Consultation Response from KC, Highways Development Management

2021/93305 61-65, New Street, Huddersfield, HD1 2BQ

Date Responded: 21/12/21

Description  
**PROPOSED GROUND FLOOR GENERAL ARRANGEMENT PLAN**

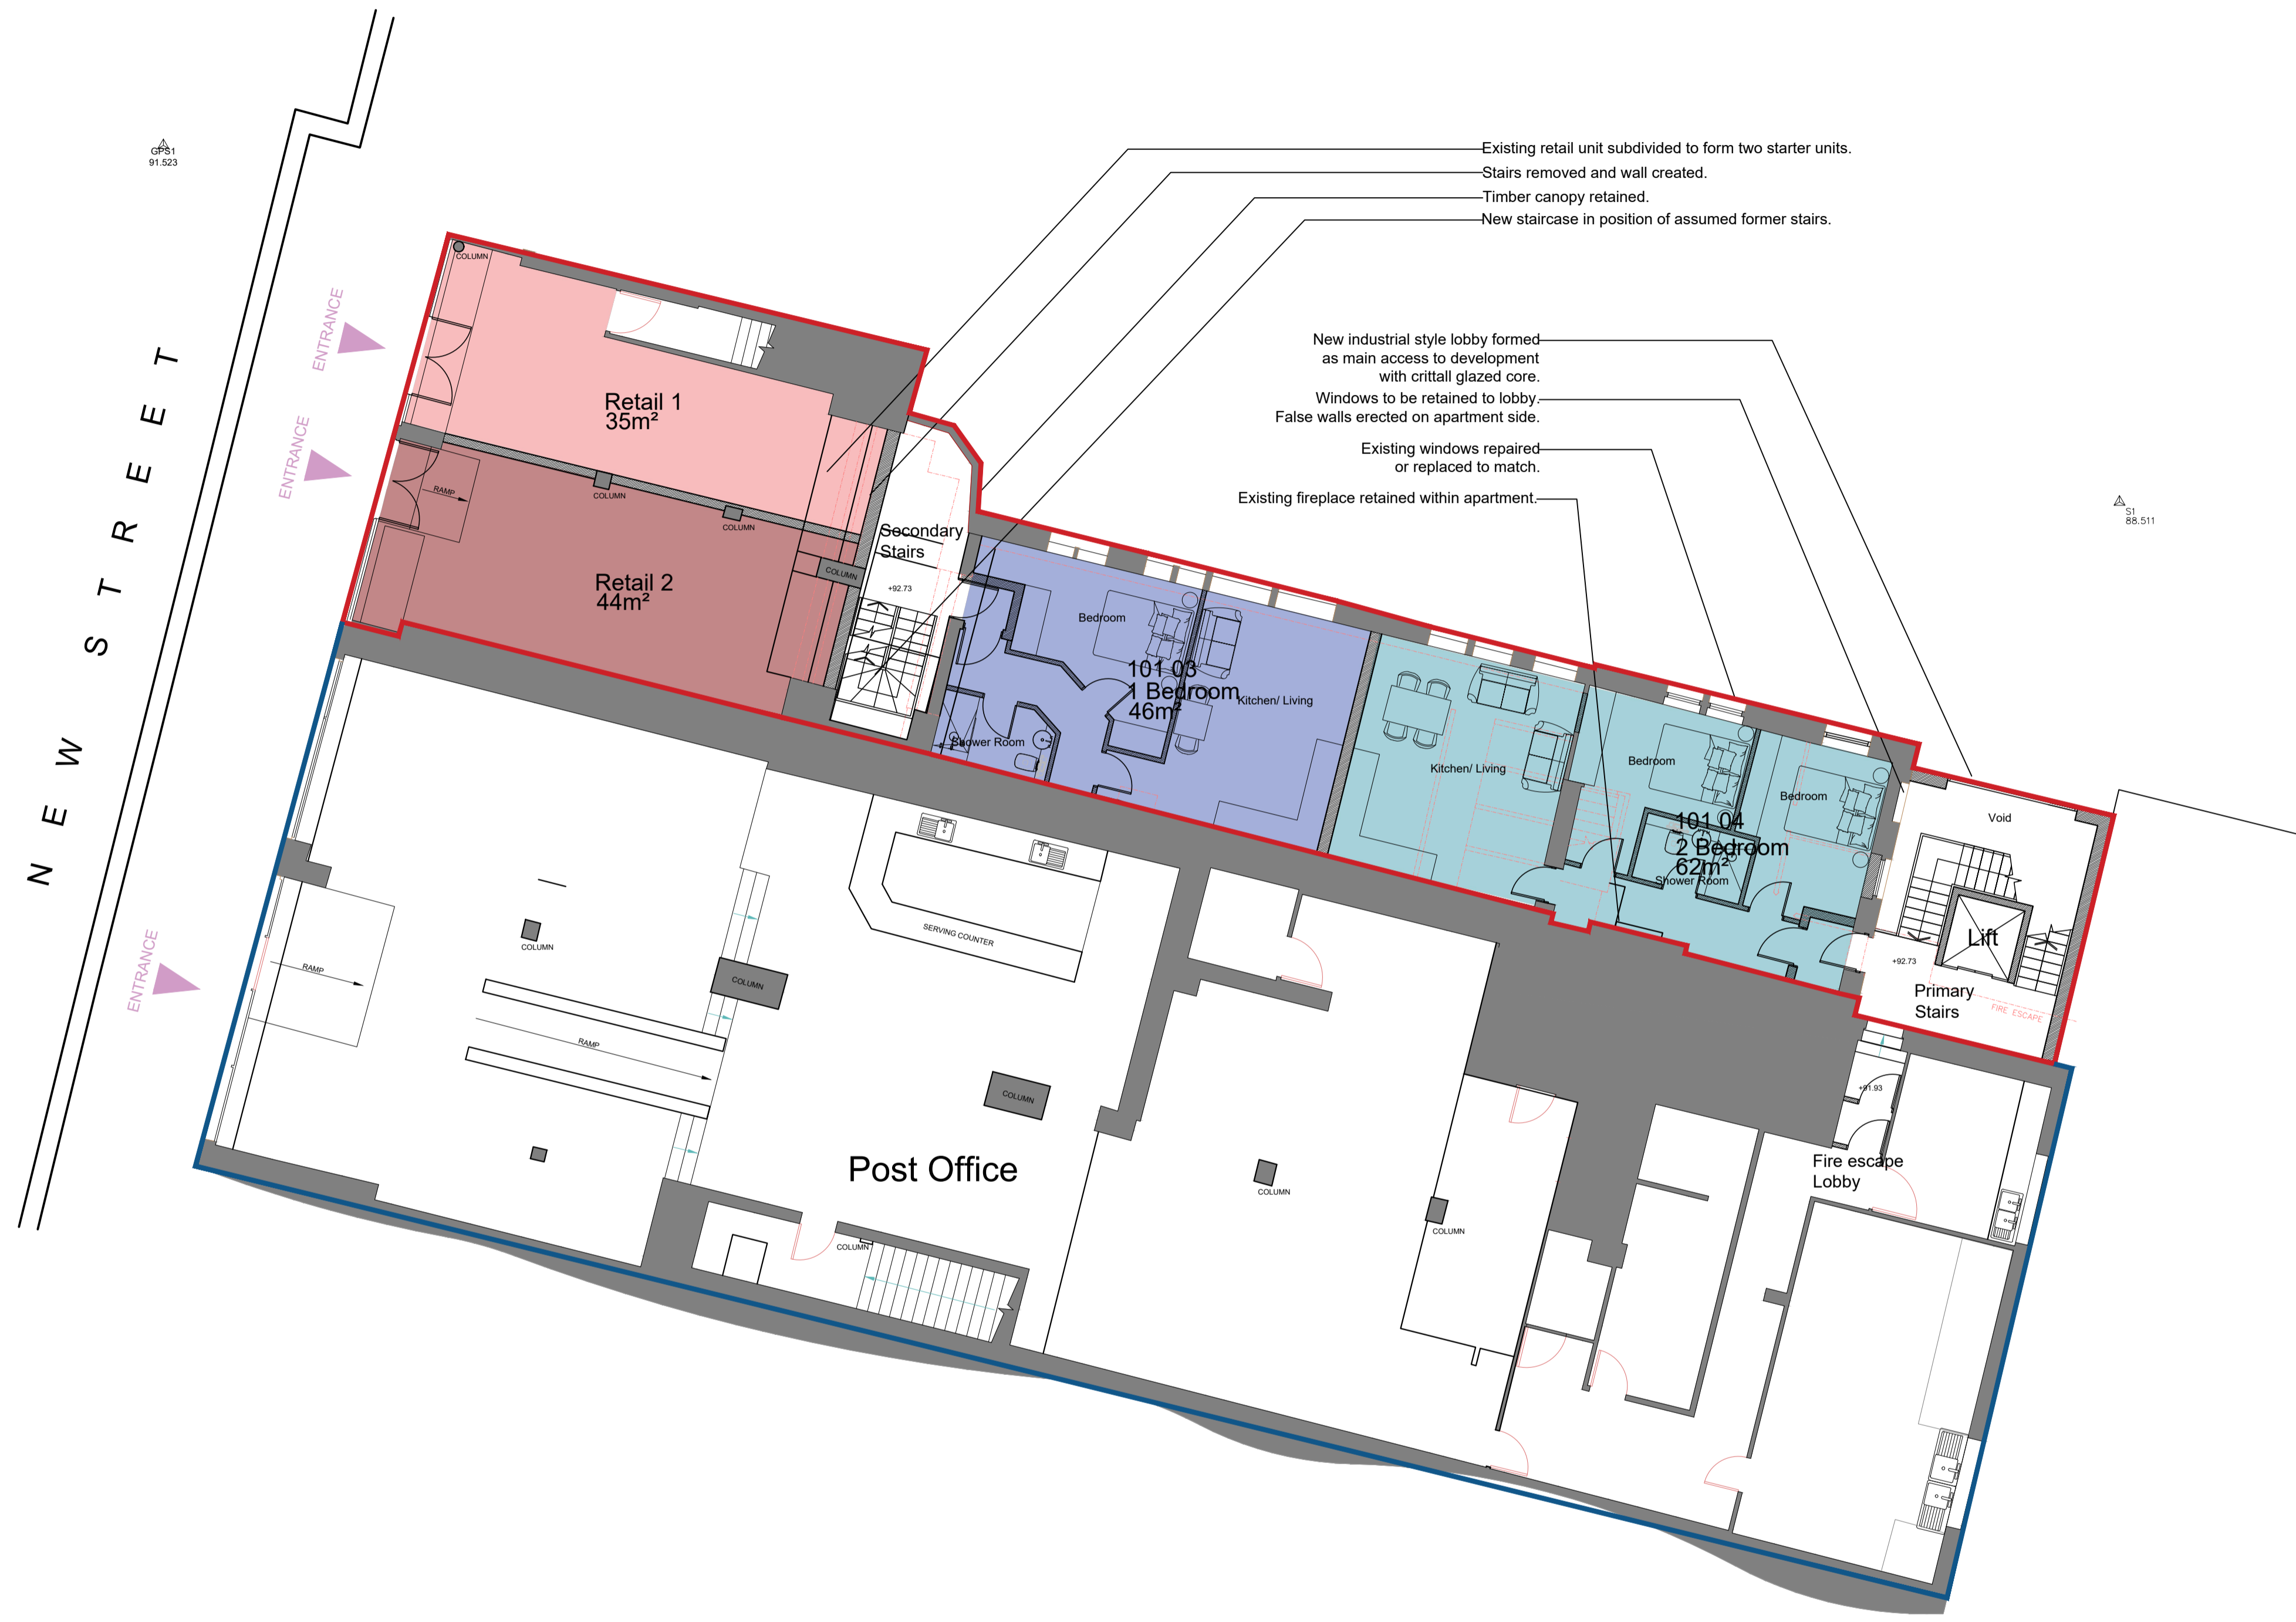
Although Highways DM has no objection to the change of use, further clarification is required in terms of cycle storage. Kirklees' Highway Design Guide SPD recommends that there is sufficient room to store one bike per apartment; it should therefore be demonstrated that the proposed cycle store has sufficient space to house 31 bicycles.
